Proposed development of a wind farm consisting of 27 turbines of up to 125m tip height and associated development

Land at Sweet Lamb Rally Complex, Y Foel, Powys

Annex 1: Natural Resources Wales's detailed comments on the draft Environmental Statement

Present view north-eastwards from Cae Gaer fort

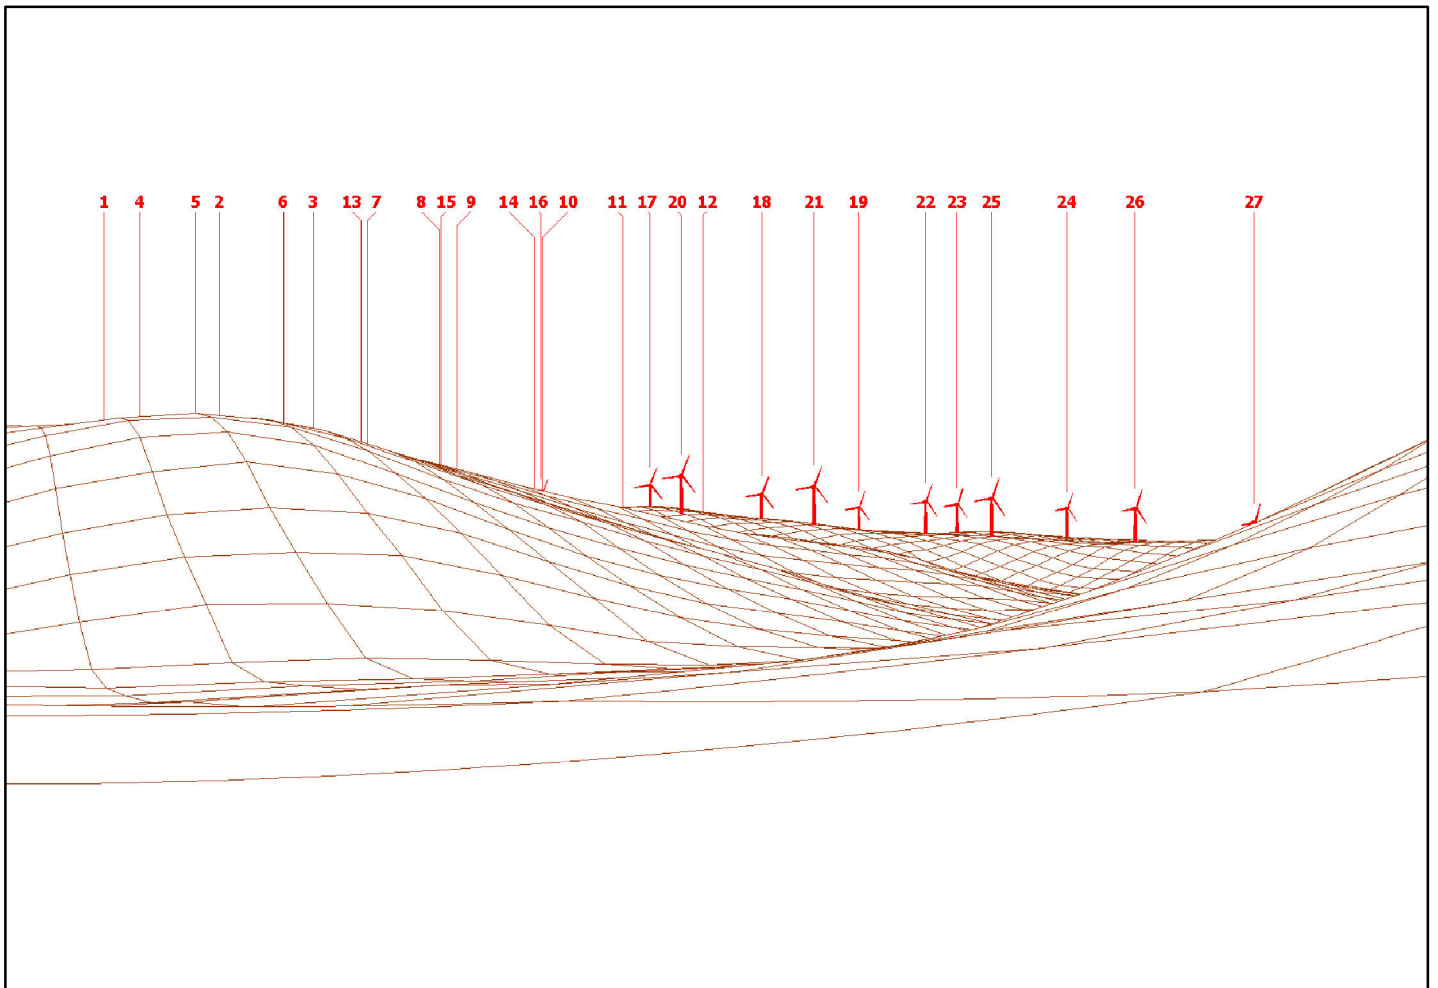
Within the Peraidd Fynydd HCA, we consider that there would be a 'Considerable' rather than a 'Slight' impact on the Cae Gaer Roman fort (HCA Viewpoint Fig. 5) at about 2.5 km from the proposed development, where the turbines would appear dominant on the skyline. The overall impact on this HCA would therefore be 'Moderate' rather than 'Slight'.
